88 Preble Street - Final Traffic Comments

Hi Barbara – I have reviewed the most current project information and offer the following final traffic comments.

DRAWN BY
SWC
SHEET TITLE
Off-Street Parking Plan

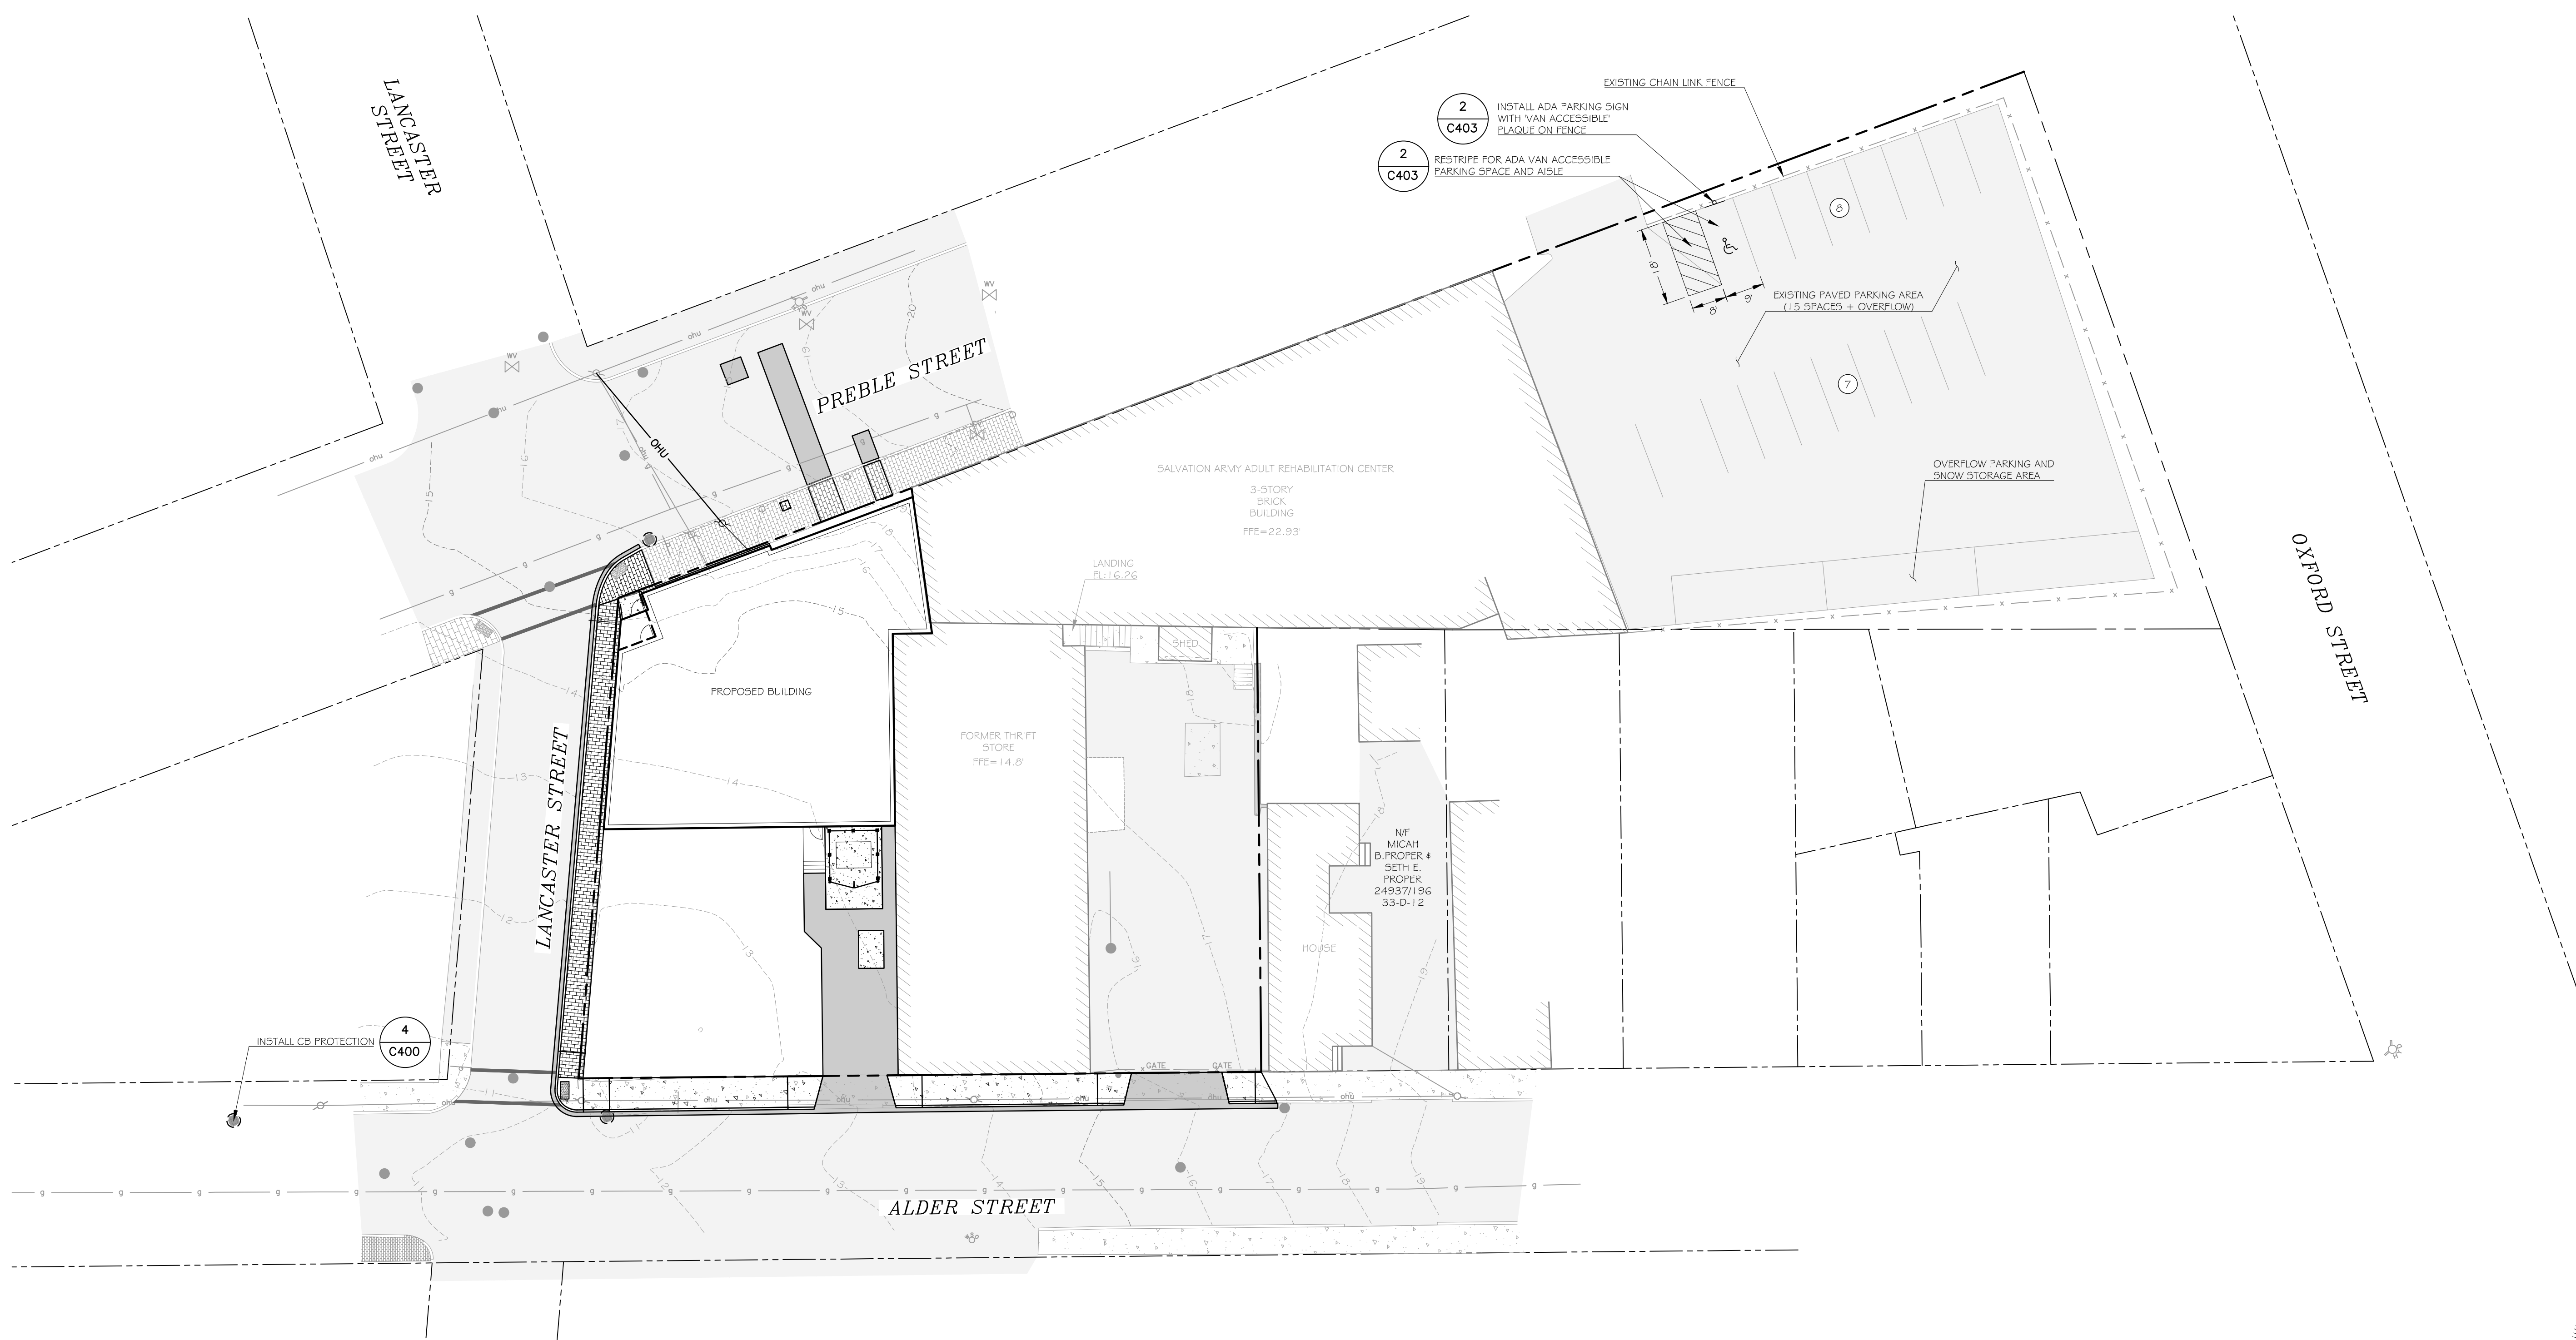
- I find the existing parking lot layout to be acceptable and support a waiver from the City's technical standards for parking aisle width.
- Bruce Hyman has provided design direction on the sidewalk ramps. The plans should be revised to reflect Bruce's comments.
